### **Durham County Council reference number: 20032071**

### **Durham County Council's Response to Examination Document PDL-013**

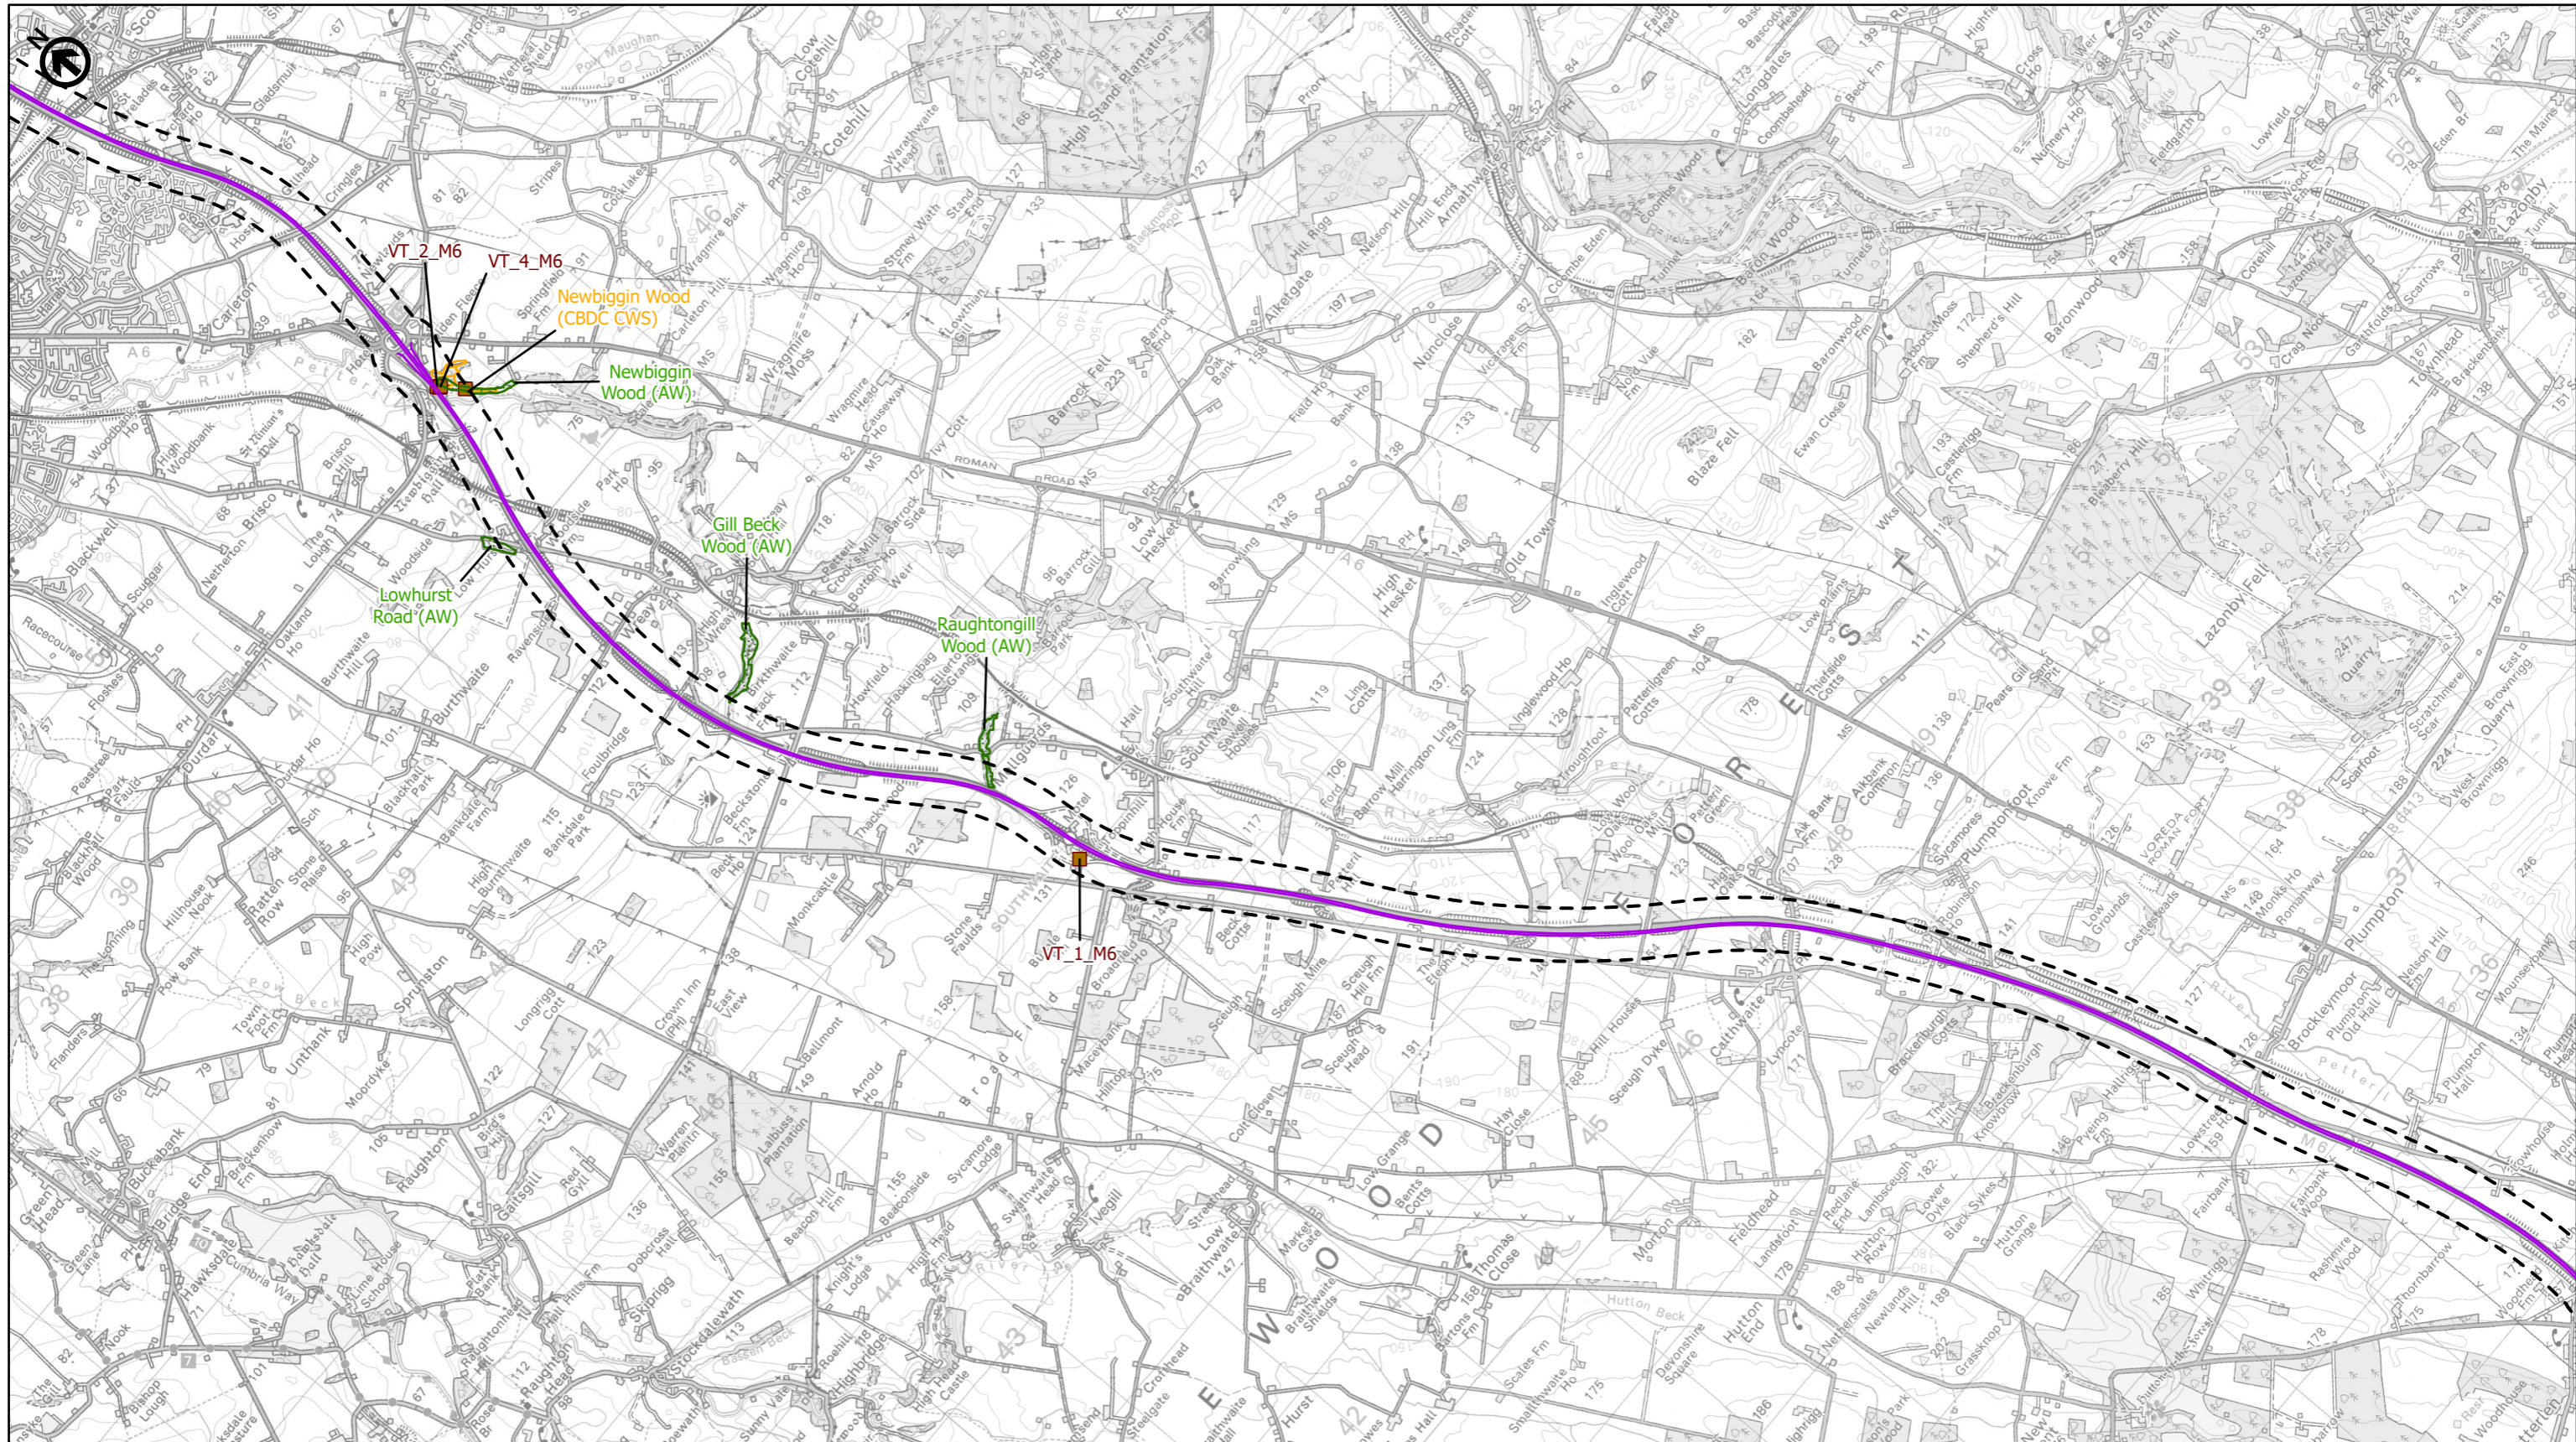
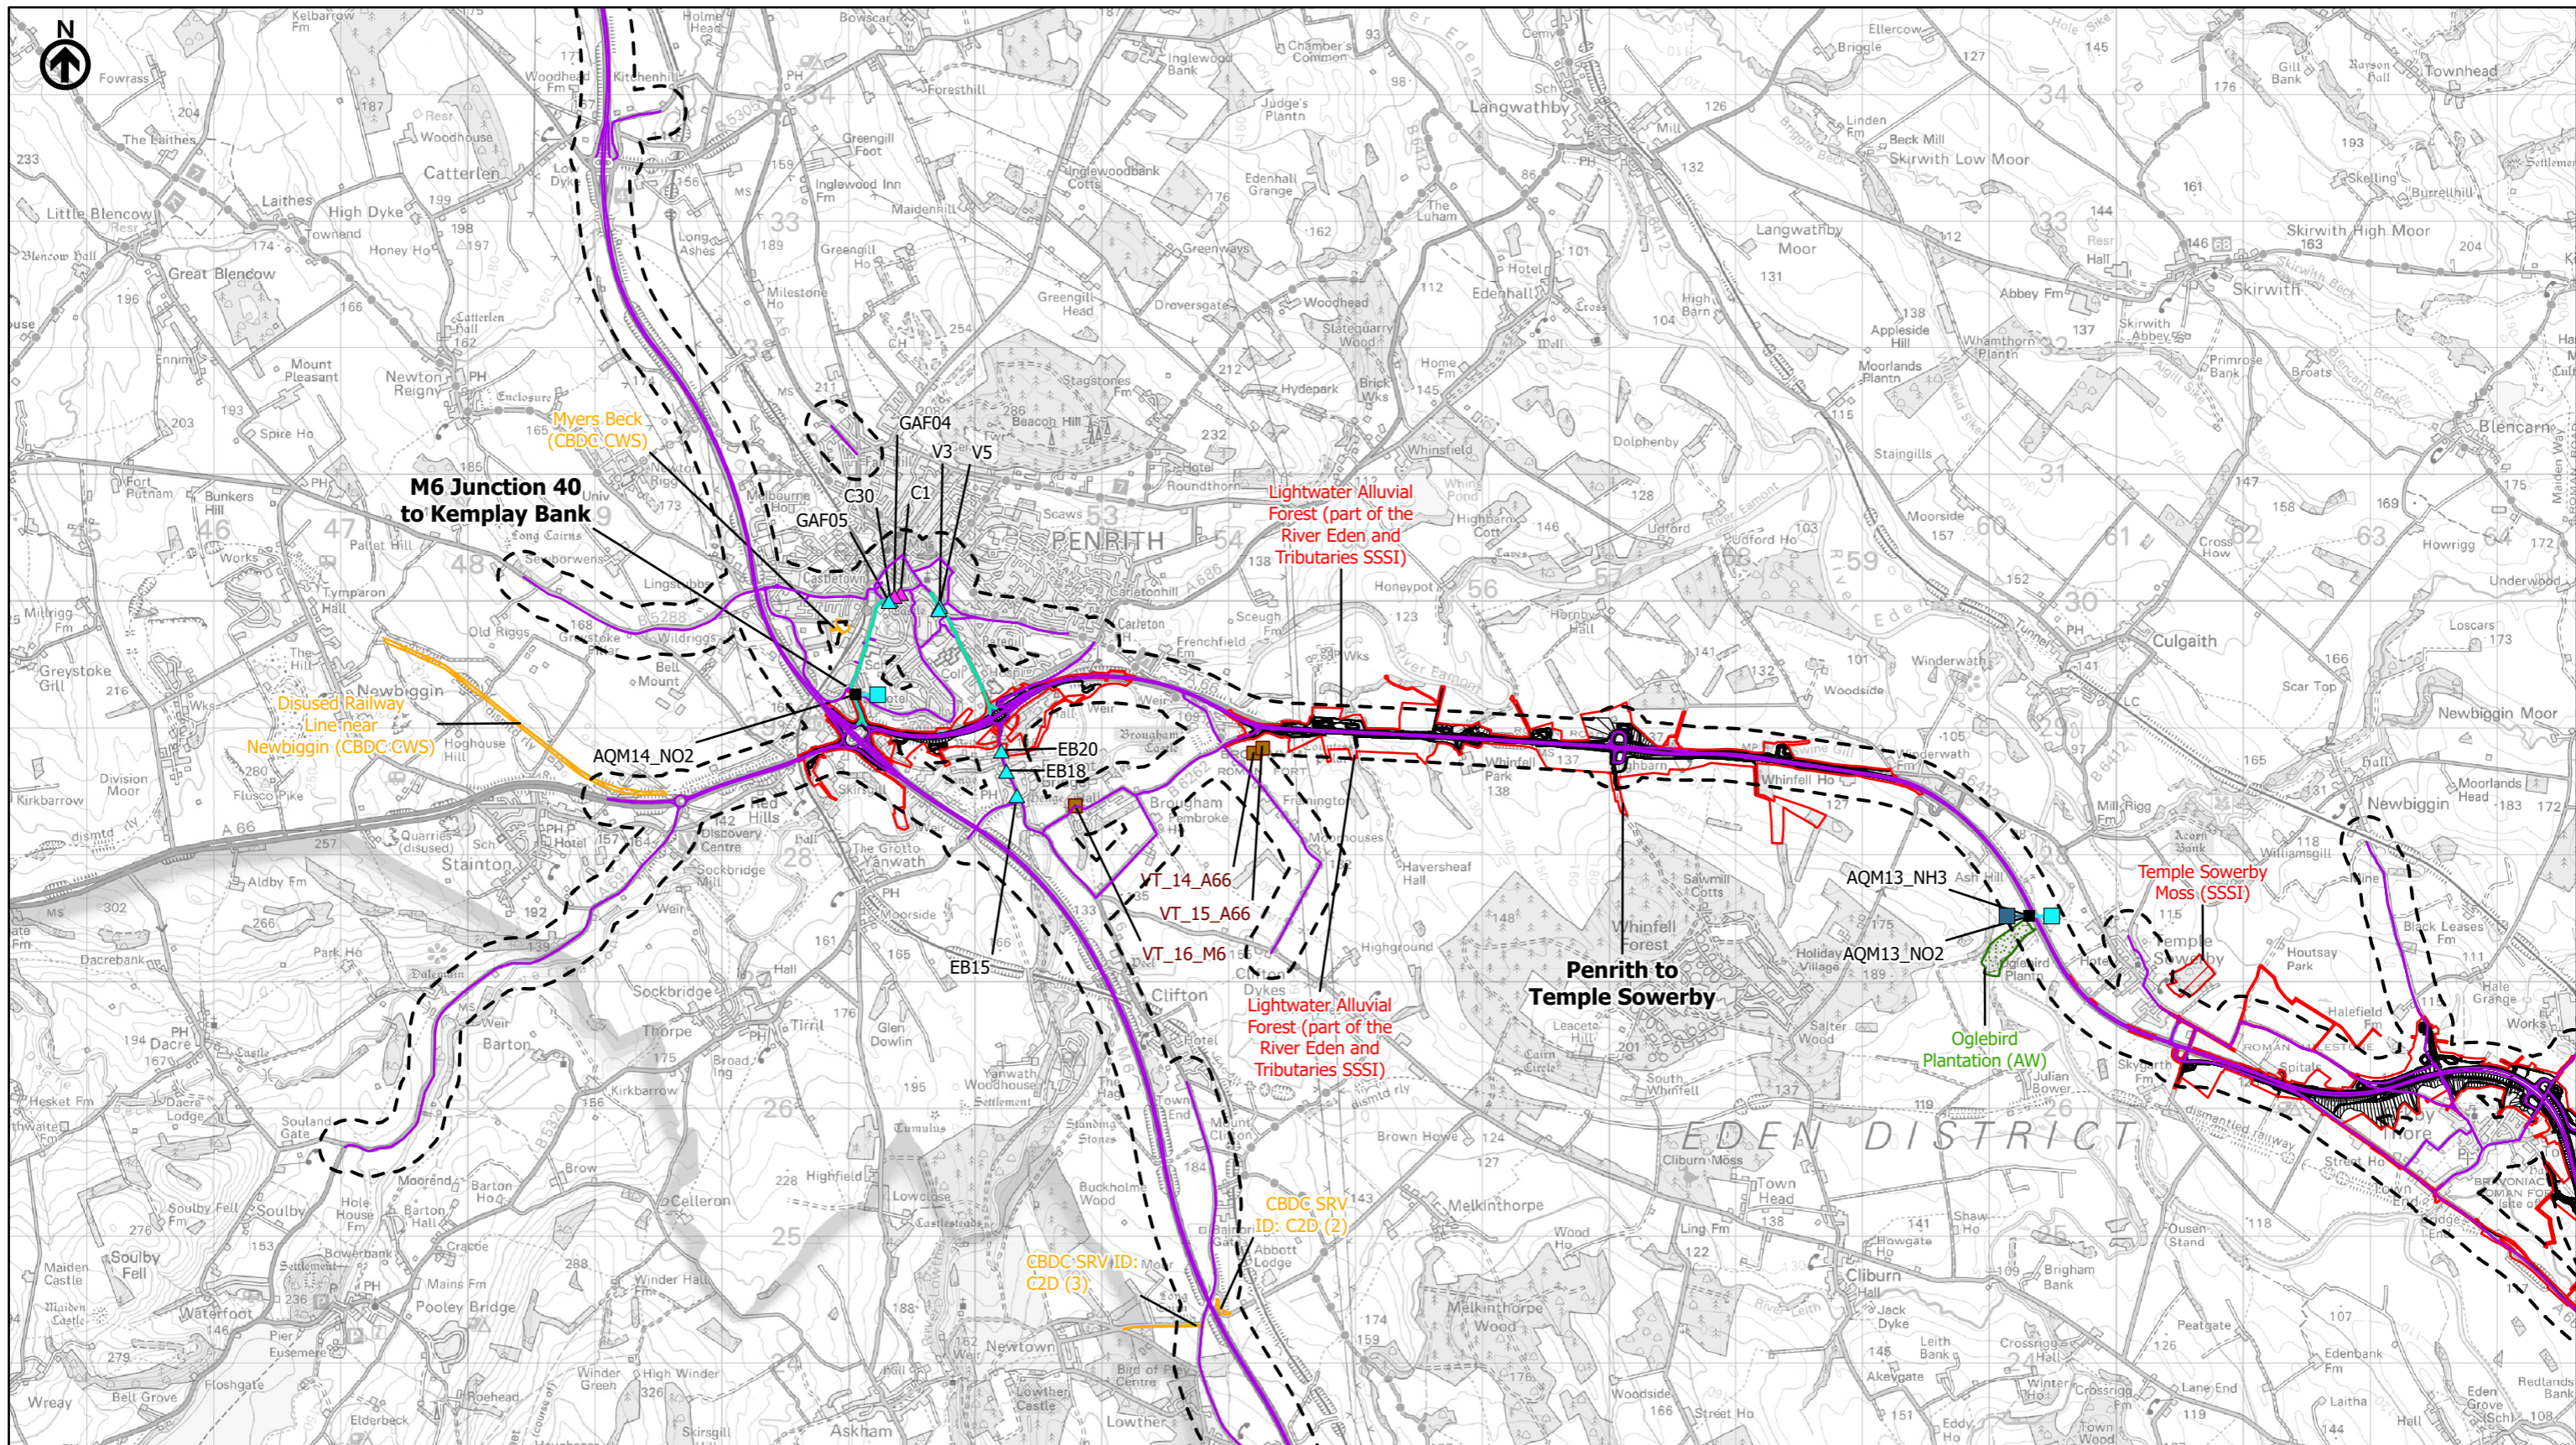
DCC response 31.08.2022	Applicant response 16.11.2022	DCC response 24.11.2022
Baseline		
<p>Baseline NO2, PM10 and PM2.5 have been presented in Appendix 5.3 Air Quality Baseline Monitoring. No Scheme specific PM10 or PM2.5 monitoring has been undertaken and it is noted that there is no nearby existing PM10 or PM2.5 monitoring in the study area within DCC. These three pollutants have been assessed for both construction and operational phases.</p>	<p>Preamble, no response necessary.</p>	<p>No further comment.</p>
<p>DCC air quality baseline has not been reported specifically to inform the baseline appreciation however considering the distance to the DCC air quality monitoring locations, this is not considered a material issue.</p>	<p>Duly noted.</p>	<p>No further comment.</p>
<p>Four months of NO2 monitoring was undertaken for the Scheme between November 2021 to February 2022 at 16 NO2 locations in triplicate; four of these locations were in DCC (AQM 5, 6, 7 and 8). DCC were not consulted on the locations or given the opportunity to provide insightful, local feedback on the locations where monitoring would be useful. Based on the level of impact indicated by document 3.7 Transport Assessment in both construction and operational phases, it would have been useful to monitor at a sensitive receptor location along the A67 in Barnard Castle, near the river bridge, where a number of dwellings are located at locations nearby the road edge.</p>	<p>The NO2 monitoring locations were informed by the findings of the Preliminary Environmental Information Report (PEIR) and were undertaken at locations where the preliminary assessment identified the likelihood of significant effects. The comments provided, relating to monitoring locations in Barnard Castle, are noted.</p>	<p>We have outstanding concern of potential air quality impact at sensitive receptors in Barnard Castle due to lack of project monitoring data. Monitoring data in Barnard Castle would be helpful to understand the air quality impact risk and assist inform key method points the assessment has taken.</p>

<p>There is no source of background nitrogen deposition rates used in the assessment provided in Appendix 5.3 Air Quality Baseline Monitoring. As per LA 105, this should be included in any reporting.</p>	<p>Background nitrogen deposition rates for the ecological sites identified in the assessment were taken from Air Quality Information System (APIS) at the time of ES drafting and assessment, as set out in Chapter 5 Air Quality (Document Reference 3.2, APP- 048) (Current Baseline - paragraph 5.7.3).</p>	<p>No further comment.</p>
<p>Defra annual mean background pollutants concentrations have been used in the assessment for 2019 and future year 2029; in grid square contribution from major road sector emissions have been removed from the background NOx estimates. This is reasonable. A comparison between Defra modelled and local authority background NO2 monitoring data has been made; this showed that Defra backgrounds were slightly lower than local authority monitored data however there is no discussion on this other than the difference is small (1 µg/m<sup>3</sup>) and concentrations are below the objective, nor any consideration discussed of factoring the Defra predictions using the monitoring. Given the low levels of predicted model result concentrations, this will not likely materially affect the conclusions.</p>	<p>Reviewer statement, no response required.</p>	<p>There are a number of methodological assumptions in the assessment that we consider not to represent a reasonable worst case. Therefore, it is not clear whether reasonable worst-case assumptions would materially affect the conclusions of the assessment.</p> <p>An assessment taking into account a reasonable worst case here would have used the monitoring data to inform the background pollutant concentrations.</p>

<p><b>No DCC monitoring or National Highways monitoring within DCC boundaries has been used to verify the model outputs against measured data. It is further understood that none of the Scheme-specific monitoring has been used for verification. Discussion would be useful in this instance to present how representative the verification is of receptors within DCC.</b></p> <p><i>At this point it has been assumed that the applicant's numbering system has been disrupted and is incorrect. Comments have therefore been addressed from this point on, on this basis.</i></p>	<p>12 and 13. There are no DCC monitoring locations adjacent to the ARN (as noted by the Interested Party in comment (2) above which they acknowledge is not a material issue). Available data from a National Highways air quality monitoring station have been used for model verification. Several administrative areas are covered by the assessment study area which is predominantly rural in nature with pockets of urban settlements; overall, air quality is good. In addition to National Highways air quality monitoring data, the model was verified using local authority monitoring data from representative roadside locations adjacent to the ARN. As noted above in response to item (13), site typology was considered and two separate verification factors, one for urban and another for rural road links (and receptors), were derived and applied. Where possible, sites with ≥75% data capture were used; where this condition could not be met, in one instance, this has been noted. The verification using the rural zone for use</p>	<p>A reasonable worst-case and robust assessment should be undertaken. It is not considered a reasonable worst case to use an adjustment factor lower than 1 to adjust any dispersion model outputs, given the ADMS software's tendency to underpredict. Relying on an RMSE of 12.6ug/m<sup>3</sup> is not considered robust, based on the guidance referenced in the ES chapter, and it is recommended that the modelling and verification that informed the assessment of construction and operational phase impacts is revisited. It is also not considered a limitation of the assessment to not use more monitoring data locations. Should DCC not monitor in this area, project specific monitoring should have been</p>
